Down East Appliance

845 - 845 Forest Ave, Portland, Maine

From: Marge Schmuckal
To: Kandi Talbot
Date: 4/8/2005 12:22:51 PM
Subject: 845 Forest Ave.

I've reviewed this project for zoning - It is located within a B-2 zone.

| JOB NUMBER: 200190-P | SHEET: 1 of 1 |

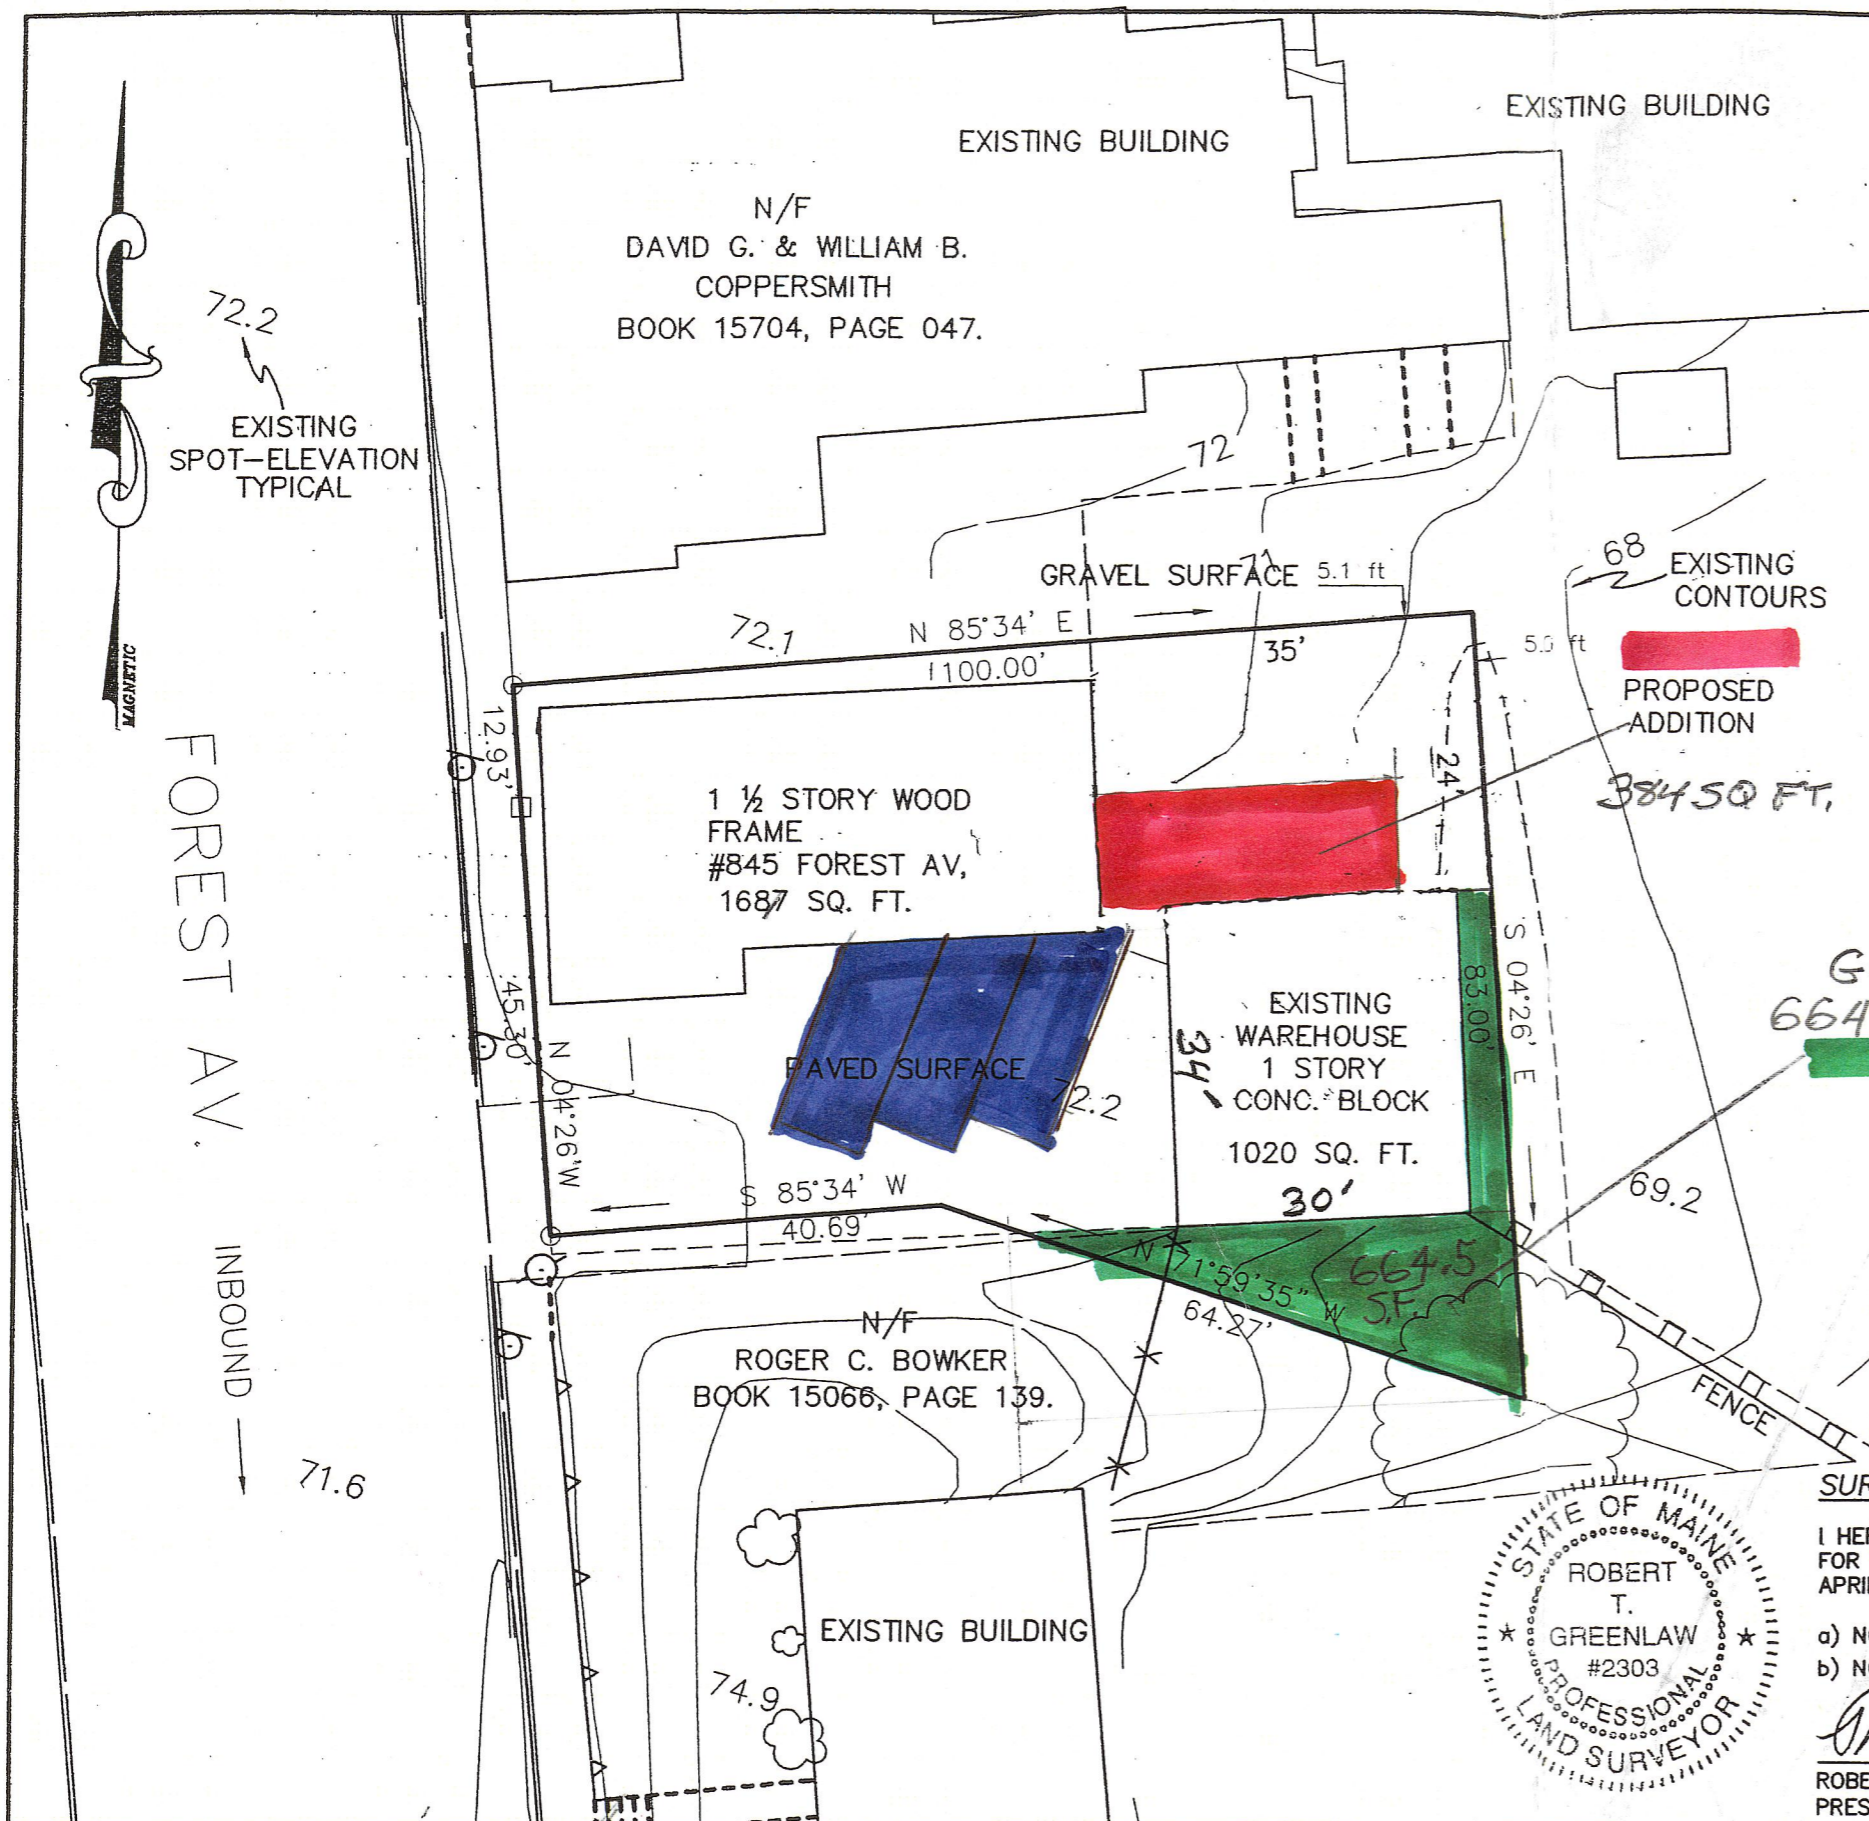
Only 3 parking spaces are required and they are showing 7 parking spaces.

The submitted plans do not adequately show before and after green space. It is undefined what the pre-development surface of the left rear of the property is. If there is no increase of impervious surface, then there would be no zoning problem. The applicant should supply the size of the denoted green space in square footage.

There is one required setback of 10 feet to the rear property line. 10 feet is being shown.
